KITITAS COUNTY DEPARTMENT OF PUBLIC WORKS

MEMORANDUM

TO: Mackenzie Moynihan, Community Development Services
FROM: Christina Wollman, Planner II *aw*
DATE: June 9, 2008
SUBJECT: JCTRS Rezone Z-08-06 and Plat LP-08-13

**JCTR LLC PLAT**  
**A PTN. OF SEC. 31, T 19N, R 19E, W.M.**  
**KITTITAS COUNTY, WASHINGTON**

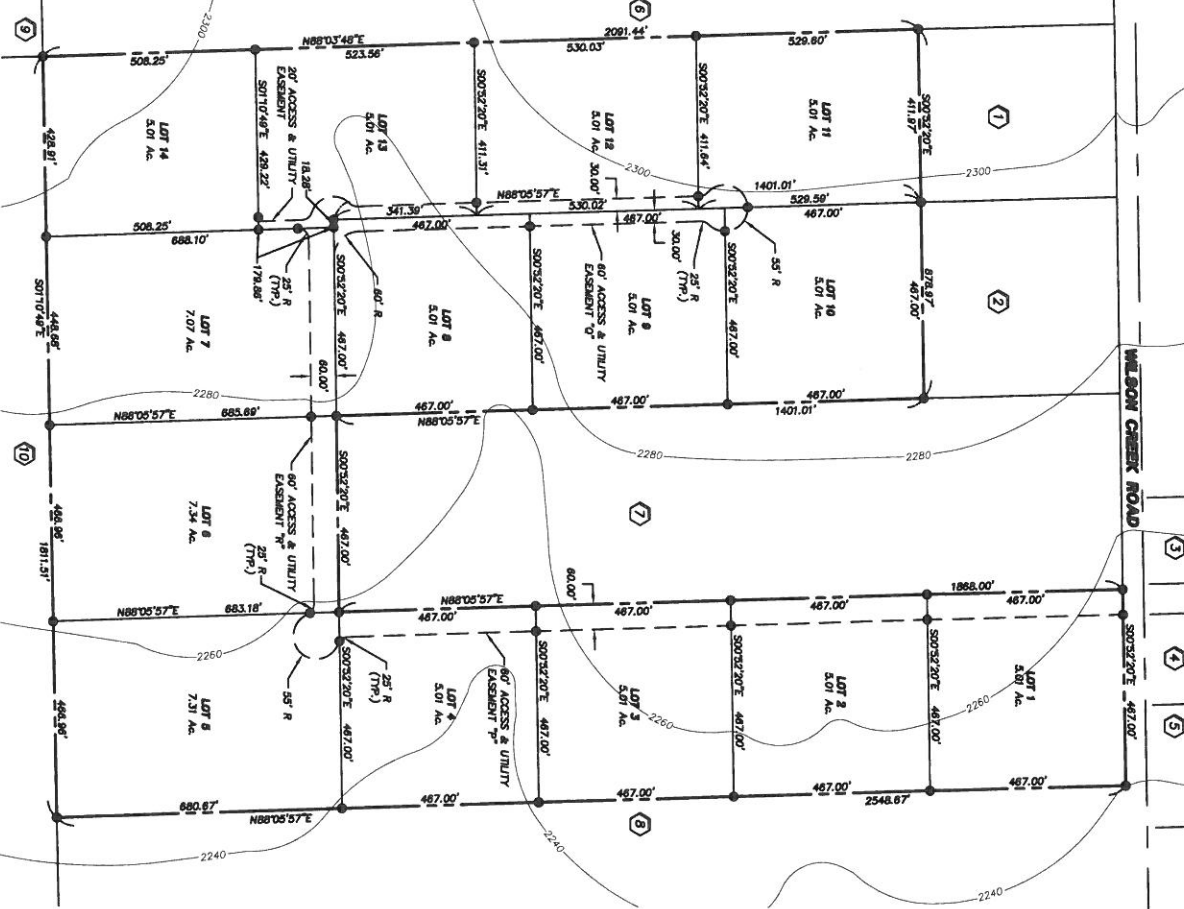
1. Right of Way: The right of way width and centerline of Wilson Creek Road shall be shown on the plat.
2. Tax Lot Number: The tax lot number listed in the Treasurers Approval Box is incorrect. The correct map number is 19-19-31051-0004. Parcel number 17624.

3. 60' Easement: The 60' easement and driveway location across the north boundary of the subject property shall be shown on the plat to accurately depict current conditions.

4. Plat Notes: Plat note #6 shall be removed from the plat, and the extra % symbols shall be removed from plat note #9.
5. Private Road Certification: Private roads serving any of the lots within this development shall be inspected and certified by a licensed professional engineer for conformance with current Kittitas County Road Standards, 9/6/05 edition. Kittitas County Public Works shall require this road certification to be completed prior to the issuance of a building permit for any of the structures within the proposed plat.
